From: Laura Gibbons <Laura.Gibbons@arun.gov.uk>
Sent: 20 October 2020 15:53
To: Planning.Responses <Planning.Responses@arun.gov.uk>
Cc: Anita Gardner <Anita.Gardner@arun.gov.uk>
Subject: M/68/20/PL- Poultry Farm 87 Yapton Road- Surface Water Drainage Comments

The application is a significant deviation from the previous scheme. Improvements to the drainage network are required. We will also require details of proposed site levels, with differences to existing levels clearly shown.

1. DRAWING PREPARED FOR THE SURFACE WATER DRAINAGE STRATEGY, NOT FOR CONSTRUCTION.
2. ALL LEVELS INDICATED ARE TO OS DATUM (METRES) FROM PROPOSED LEVELS RECEIVED.

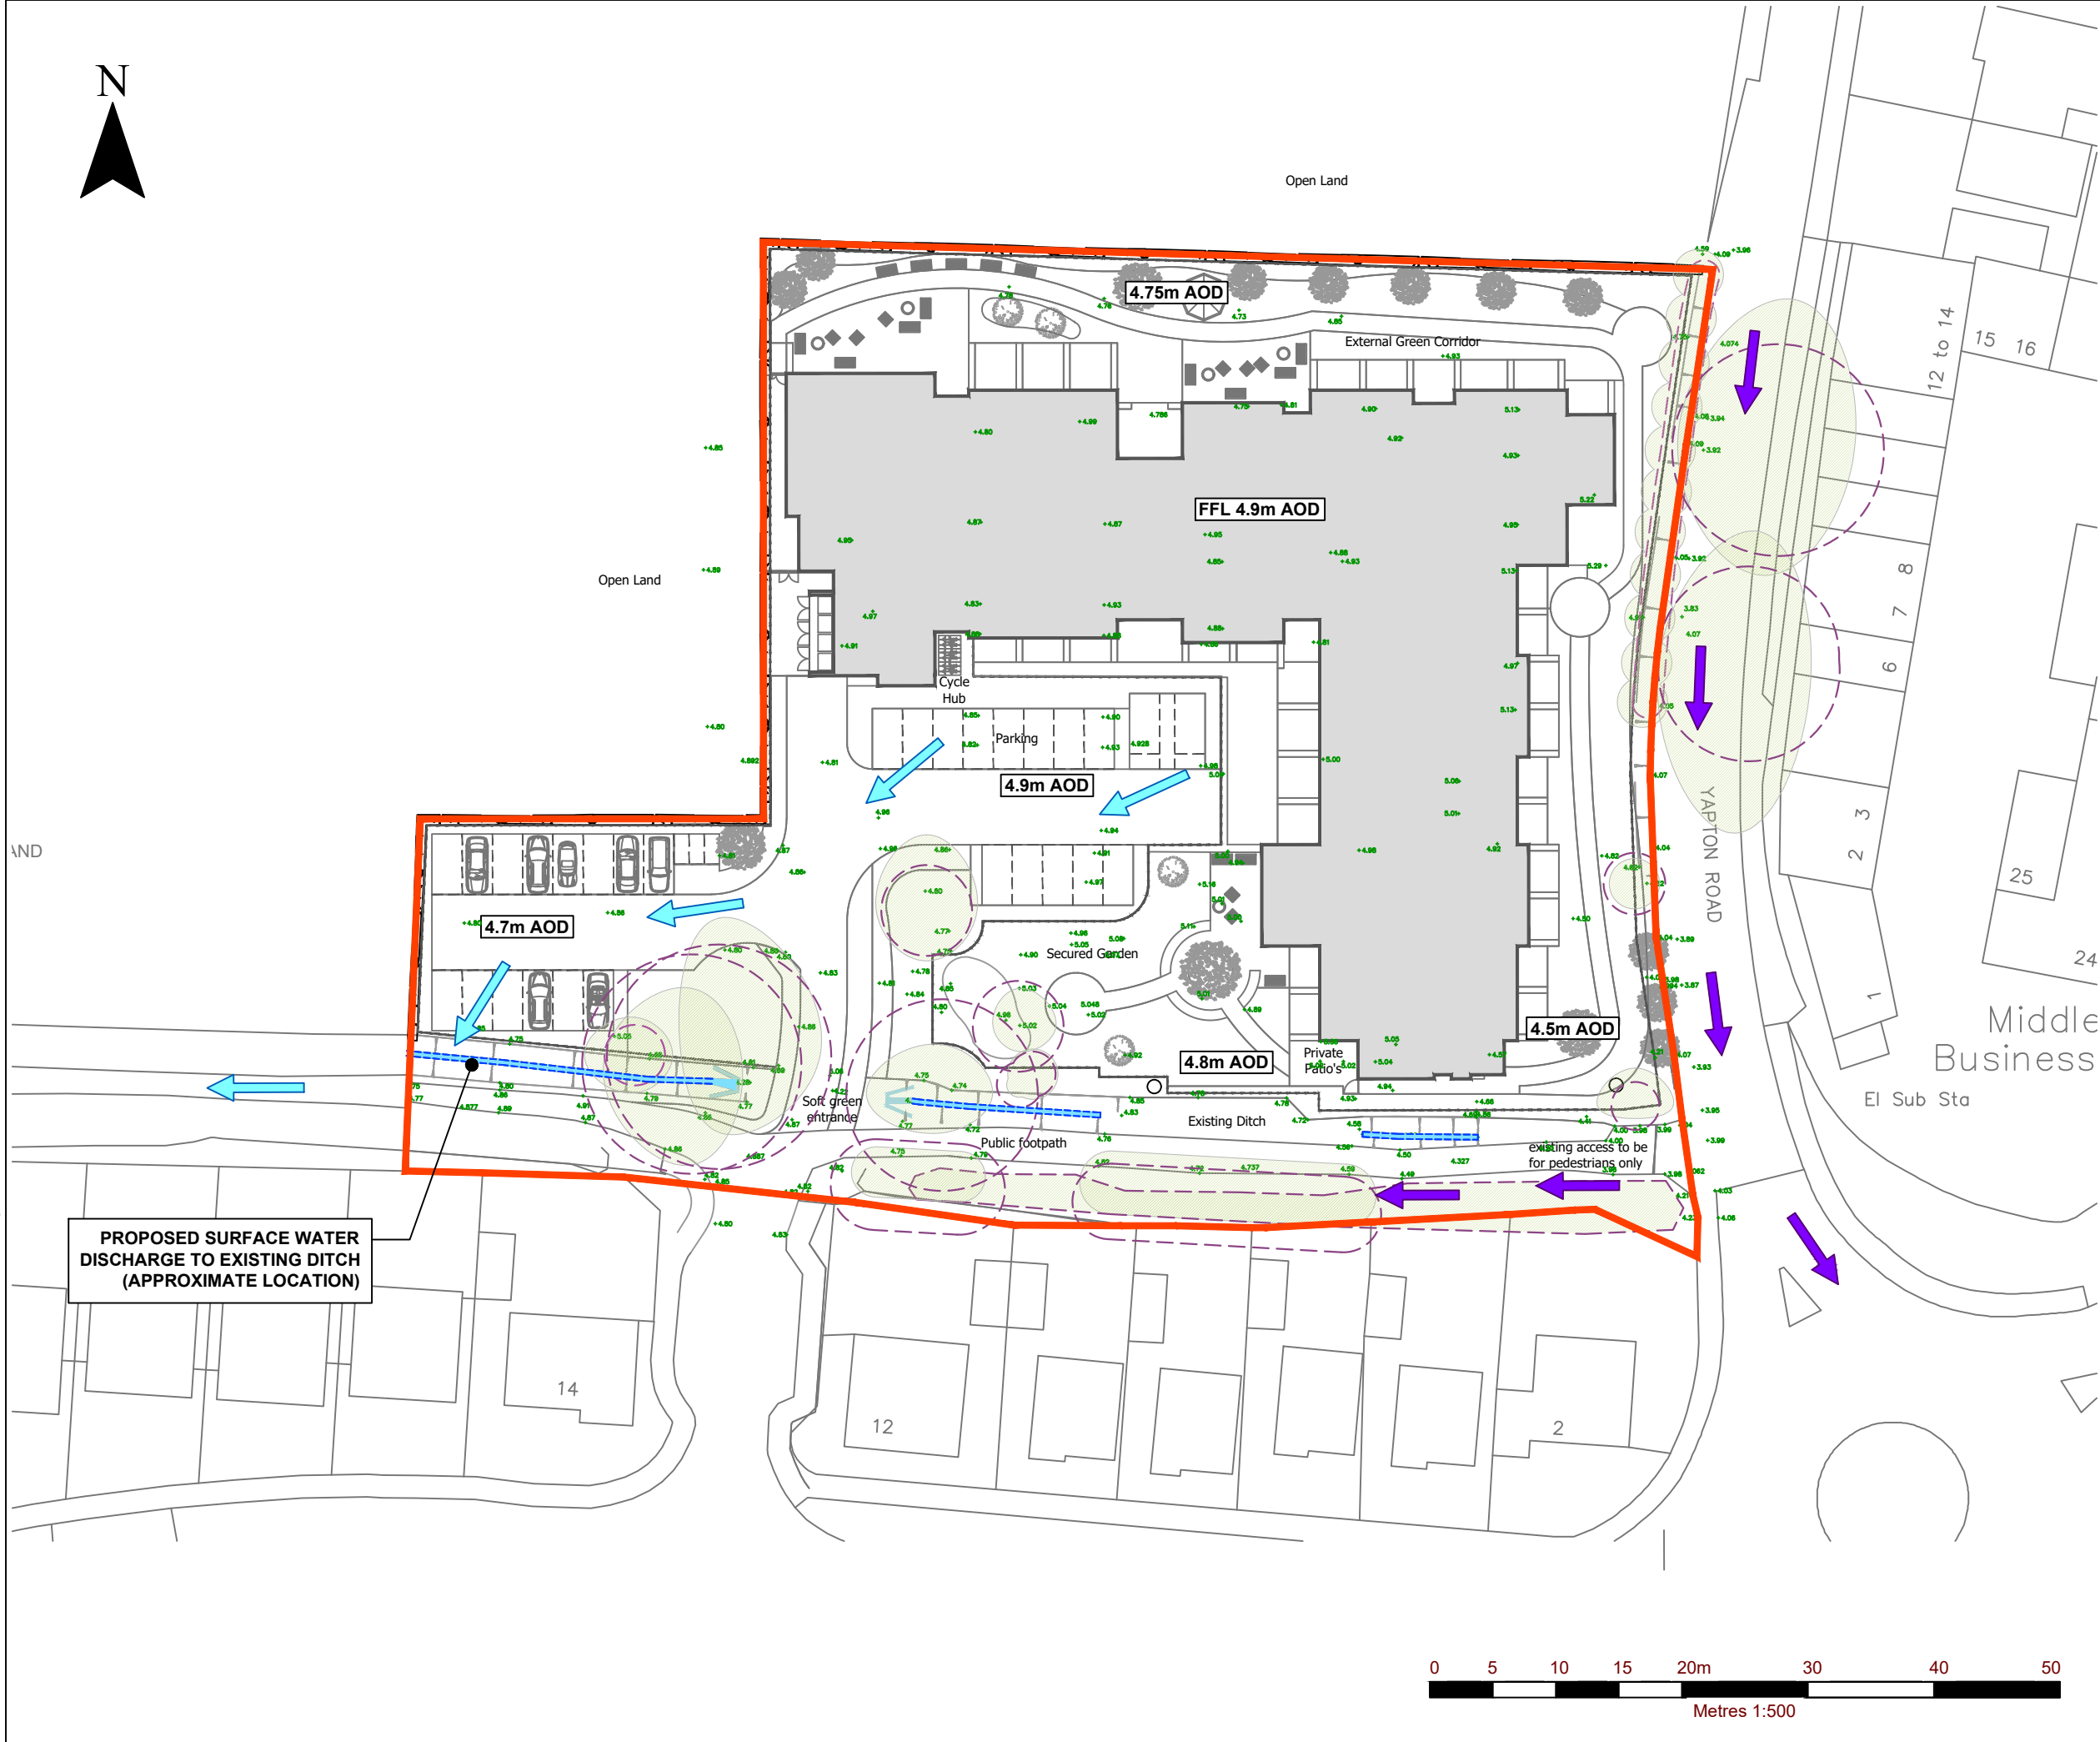
Proposed crates must be kept at least 3m from top of bank of ordinary watercourses. We have concerns regarding conflict between the draft drainage strategy and trees. On this basis we wish to place a **holding objection** on this application. It has not been demonstrated that there is adequate space within the proposed layout for surface water drainage. It is essential to establish if there is adequate space for surface water drainage prior to agreement of site layout. Drainage should be a fundamental consideration in design. Failure to secure a robustly evidenced implementable drainage strategy at this stage will likely unduly prejudice the drainage design and result in proposals failing to meet policy requirements.

A drawing that clearly shows trees that are to be retained, the root potential areas and the proposed drainage.
